Our Ref: 15756
DPE Ref: SSDA 7317 MOD 5

SSDA 7317 MOD 5 – RESPONSE TO SUBMISSIONS

This Response to Submissions (RTS) letter is submitted to the Department of Planning & Environment (the Department) in support of Modification 5 to amend State Significant Development (SSD) consent SSD 7317 relating to the construction of a commercial campus at the Australian Technology Park, Eveleigh.

drawing title
TRAVELATOR PLAN AND DETAILS

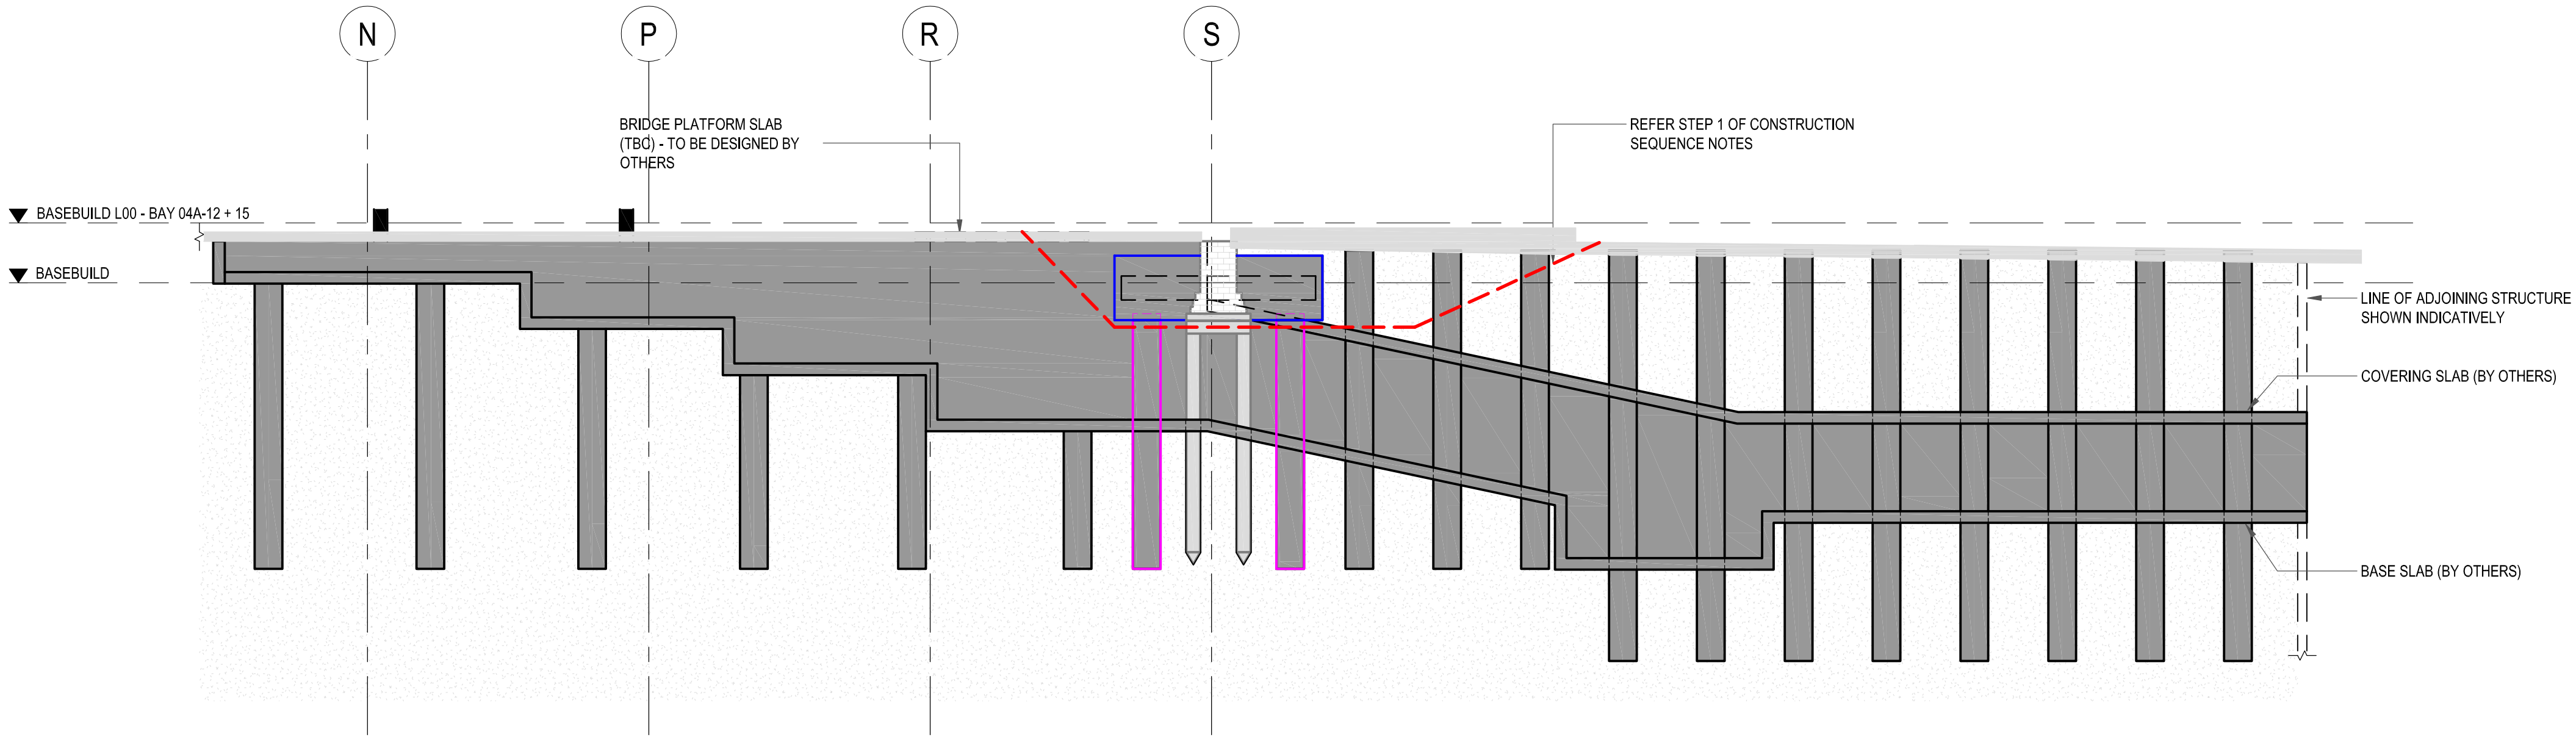
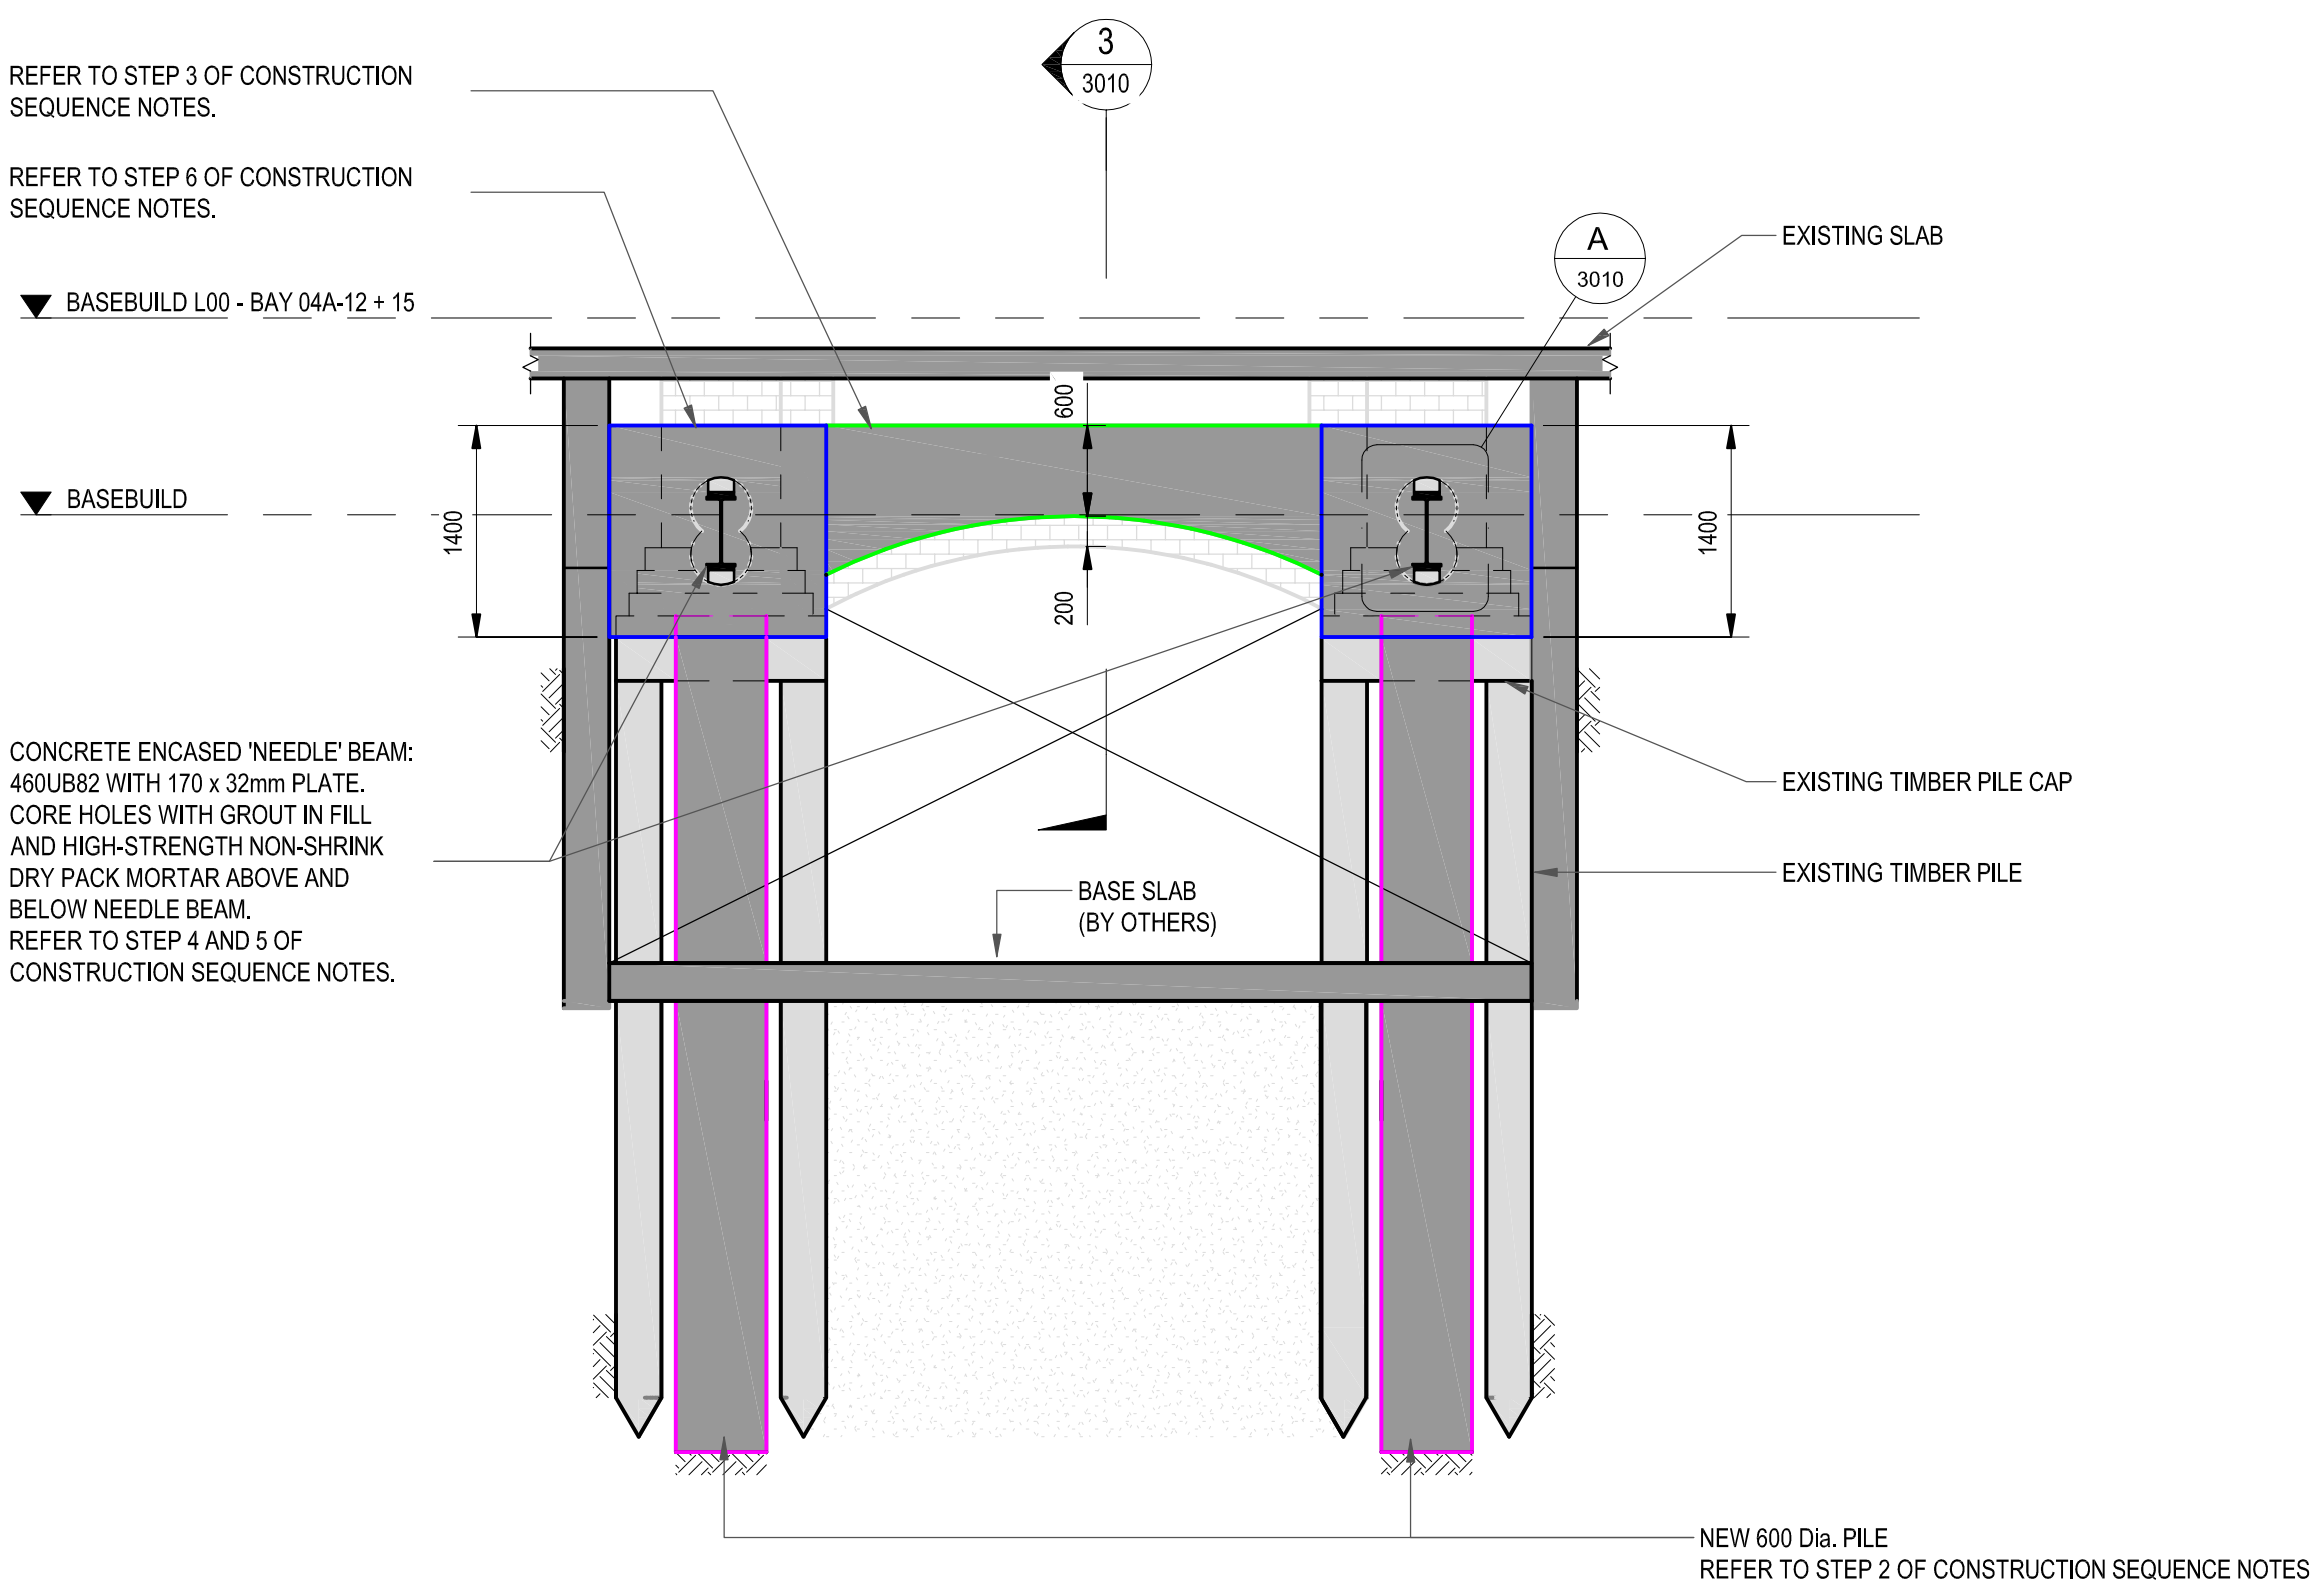
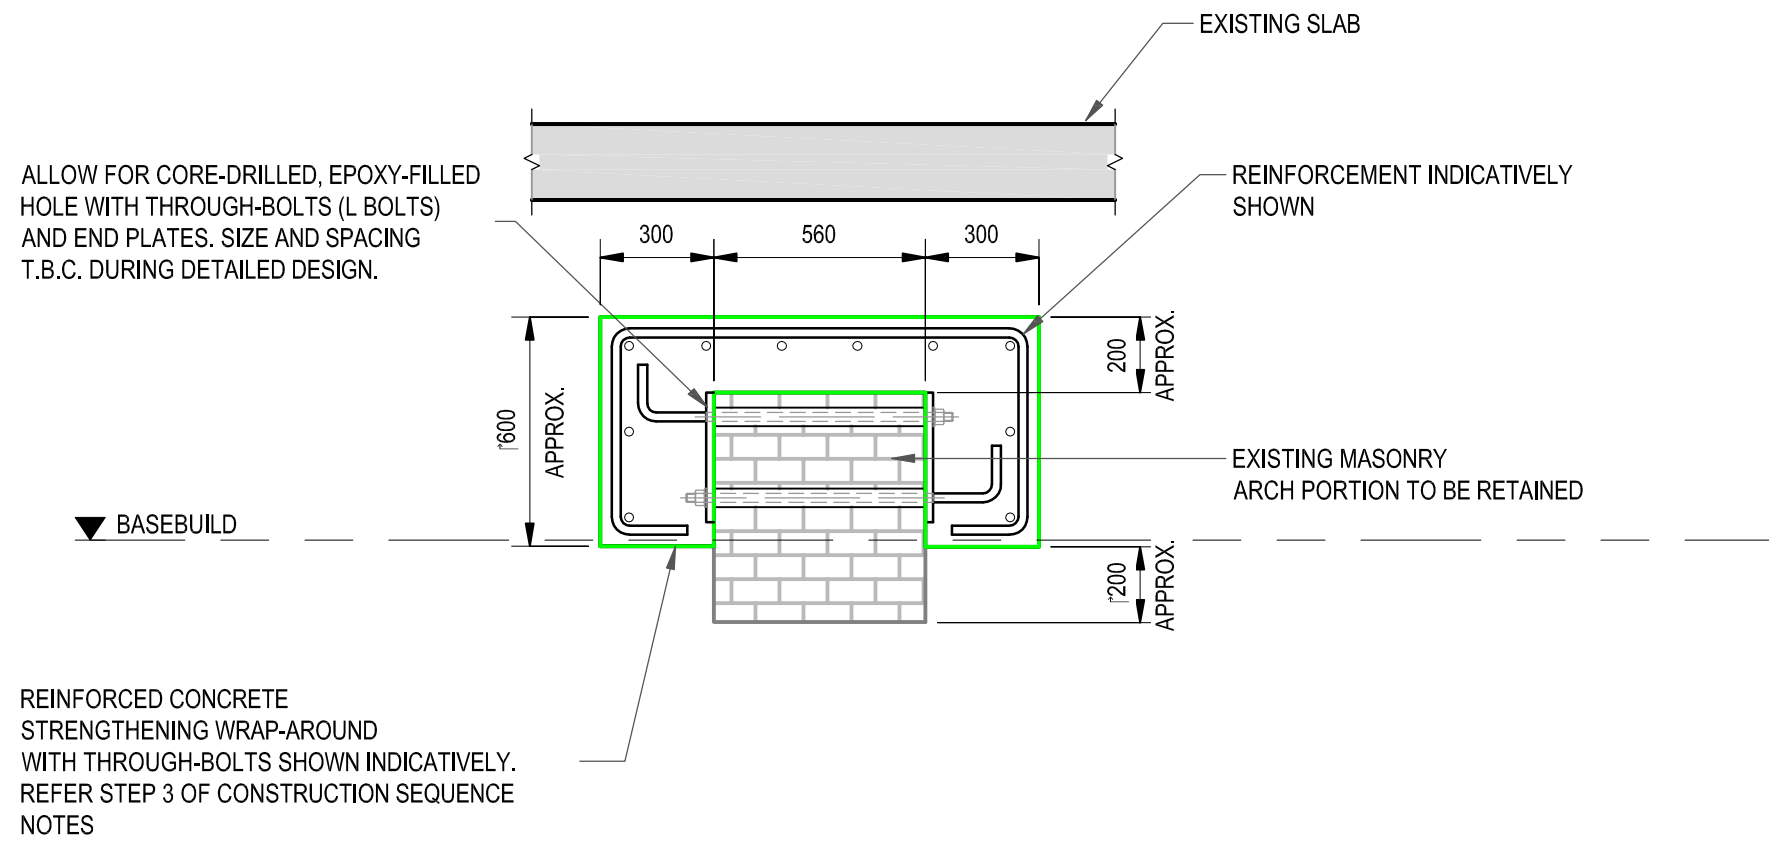
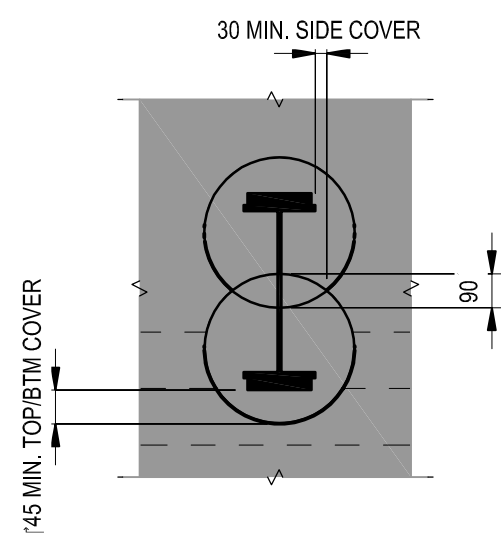
Provide further details to demonstrate the shoring concept and other structural works required to protect the stability of the Locomotive Workshop and Building 2.

Furthermore, with regard to the Locomotive Workshop, Arcadis has provided an updated Structural Assessment Statement and a Structural Details Plan (**Attachment D**) that illustrates the shoring concept and structural works that are required within the Locomotive Workshop. However, the final detailed shoring plans will be provided with the relevant construction certificate documentation for the construction of the tunnel under SSDA 8517.
